Application No: FG/196/21/HH
Site Address: 9 Telgarth Road Ferring BN12 5PX
Description of works: Erection of single storey side infill and rear extension, hip to gable roof extension to include 2 x side dormers, installation of front porch canopy and alterations to fenestration/openings.

Thank you for your internet representation made on 27th December 2021 which has been recorded as an objection with the comments as follows:

A :: Proposed North Elevation
02 scale: 1:100

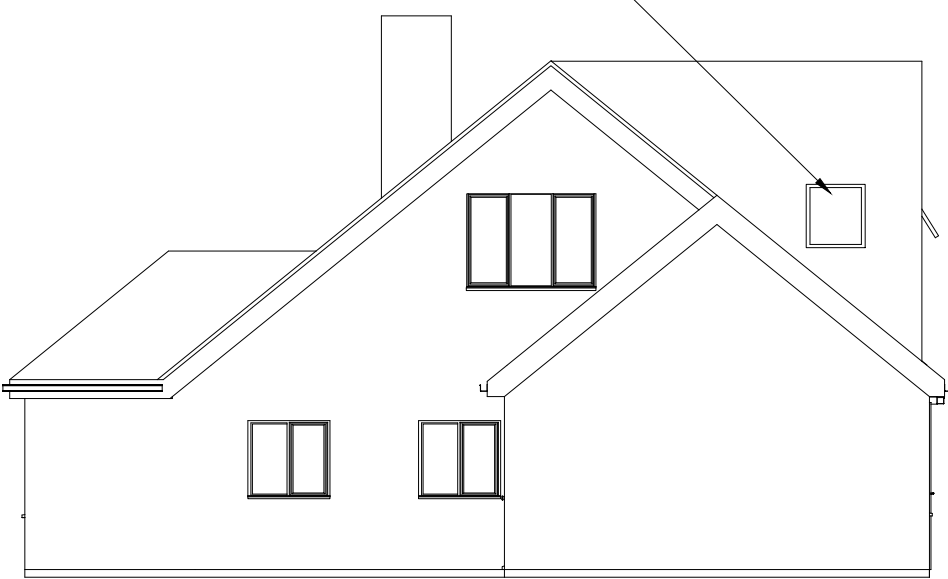
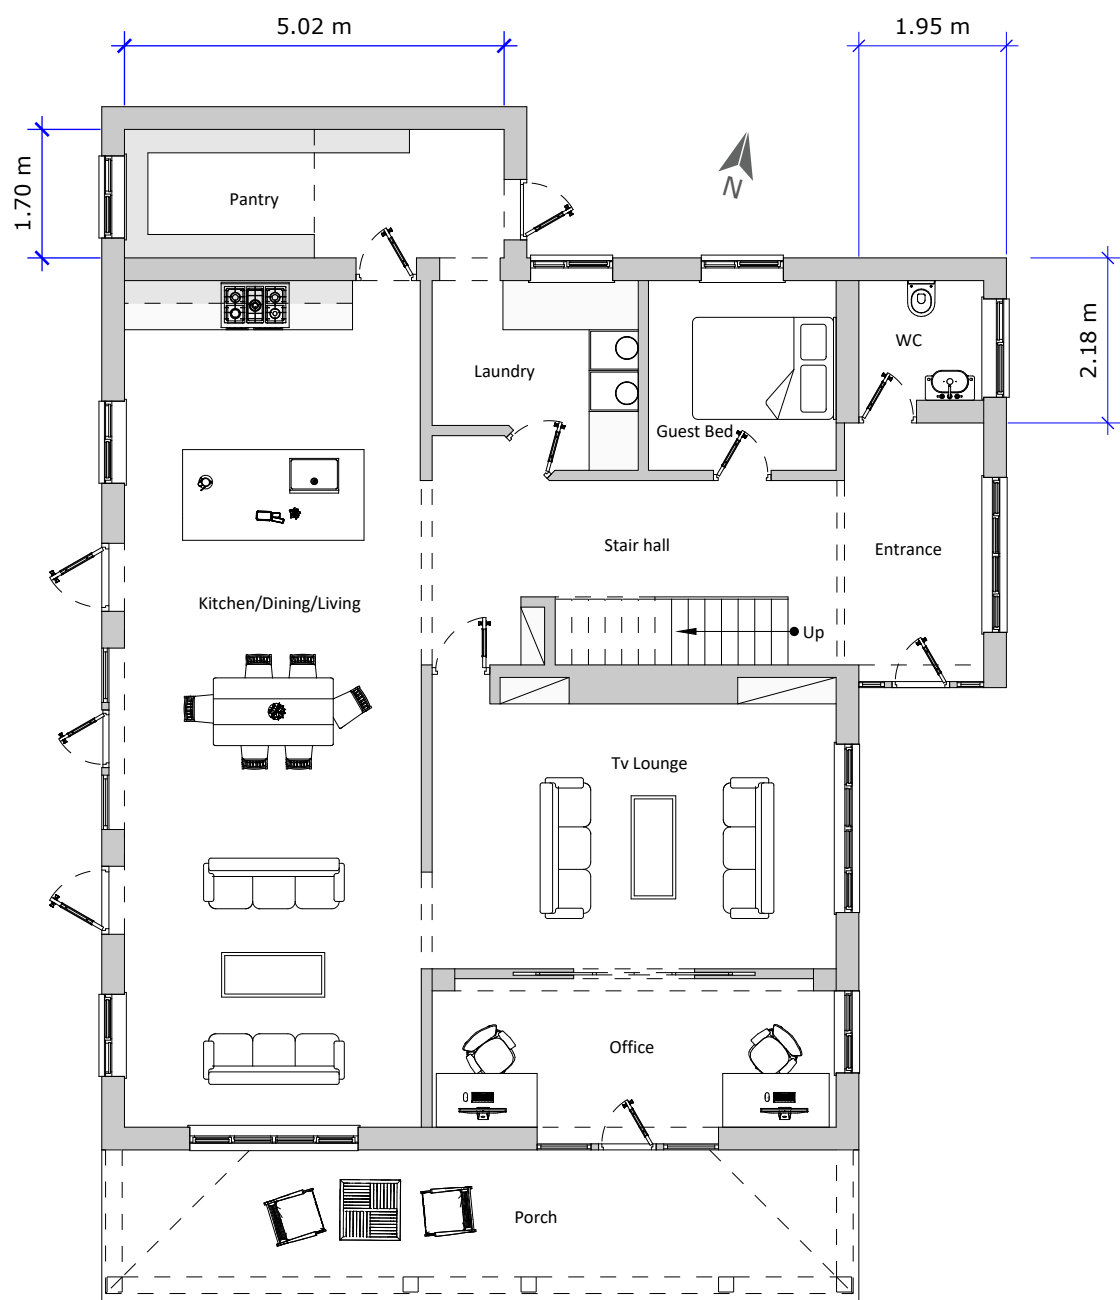
I am the new owner of a property which abuts 9 Telgarth Road to the north and am reluctantly drawn to raise an objection to the current planning application because of the scale of the enlargement of 9 Telgarth Road on its north side effectively to form a 2 storey extension. The current ridge line will seemingly be extended by some 5 metres northwards towards our property to form a 2 storey gable end of some 7 metres in height which I feel because of its proximity will have a dominating presence.

Additionally the current roof structure of the said property just allows winter sun into our ground floor south facing windows and their environs as it passes beyond the existing ridge, whereas the proposed raised height would mean a loss of sunlight for a meaningful daily period, bearing in mind also that the proposed northern most dormer similarly intercedes with this crucial sun angle.

Obscure Glazed Non
Opening Below 1700mm

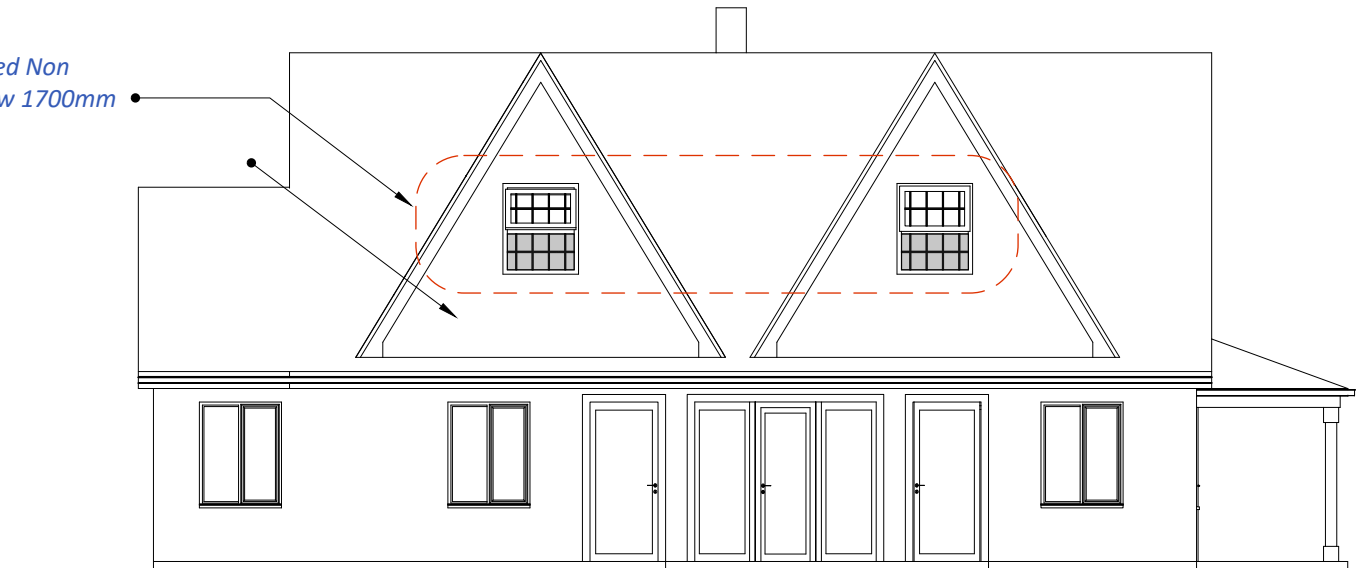
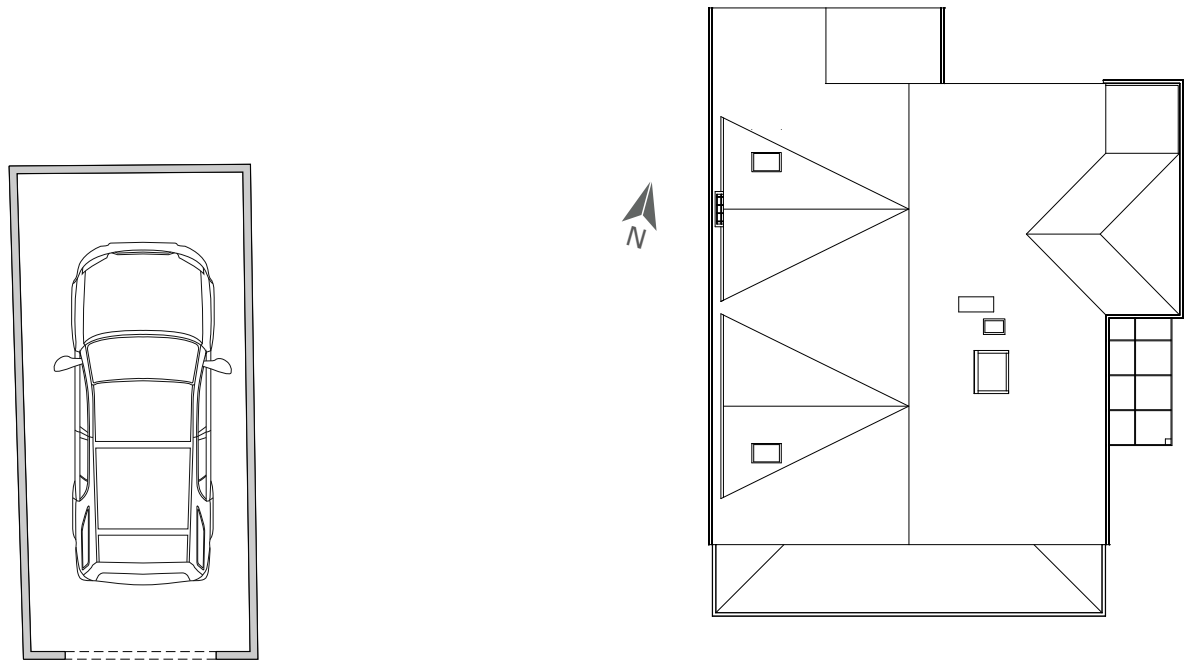
On the separate matter of windows and over-viewing this application provides for bathroom windows directly over-looking our south elevation and side, front and rear gardens and I would therefore request that any planning permission granted for whatever future re-development, stipulates that the glazing to such windows be obscure with ventilation limited to fanlight / tilting only : similarly the roof light to the northerly dormer In conclusion I object to these proposals in their current form on the grounds that the proposed northern enlargement above eaves height would I contend lead to an unsympathetic design and loss of amenity
